**ANNEXURE 2.0b**

**COPY OF AGENCY RESPONSES TO DRAFT PPR**

## Comments – Preferred Project Report

RECYCLE STORAGES

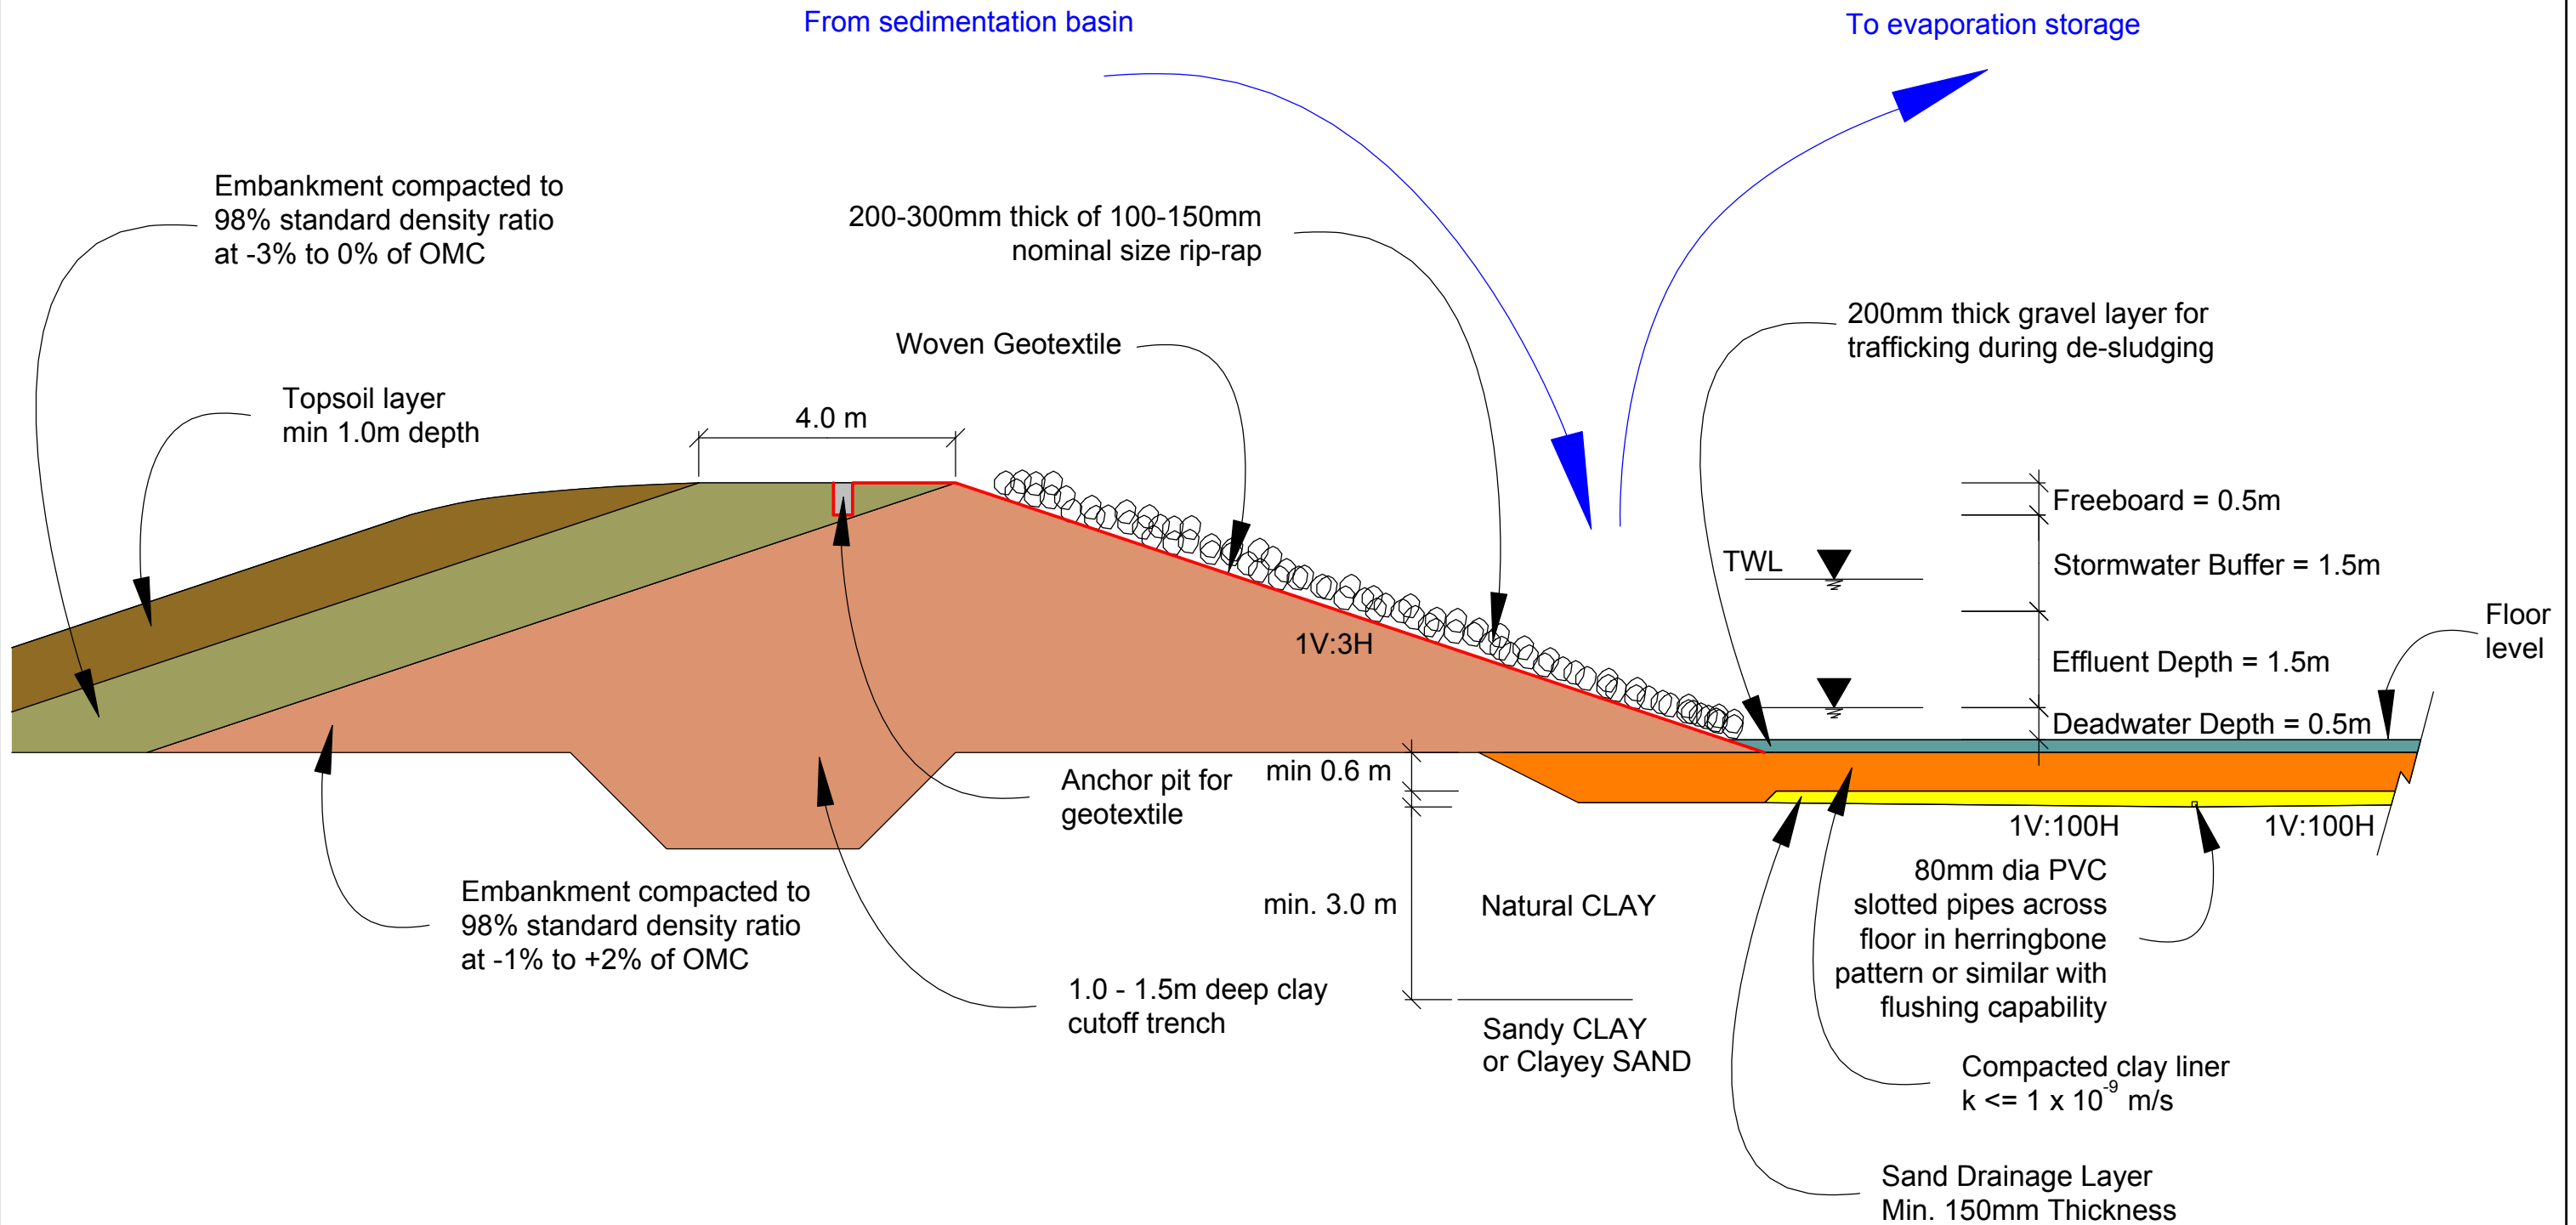
- a discussion on the depth of the cut required for the recycling and evaporation ponds and the depth of "clay" under these ponds (this information was provided in the EA for the anaerobic and aerobic ponds). This should be justified with a sufficient amount of soil cores that show a minimum of 3-4 metres below where cuts are proposed.

- As already stated, all wastewater ponds must be certified by an appropriately qualified engineer. Given the quality of the groundwater resource, appropriate collection and monitoring systems should be designed to safeguard against pond leakage. Afterall, an impermeability of  $1 \times 10^{-9} \text{m/s}$  is the standard compaction for

wastewater ponds but even this compaction is likely to still result in some leakage. Whilst it is minimal, the long term nature of the project and quality of resource beneath it, in DWE's opinion warrants special protection through a leakage and collection system.
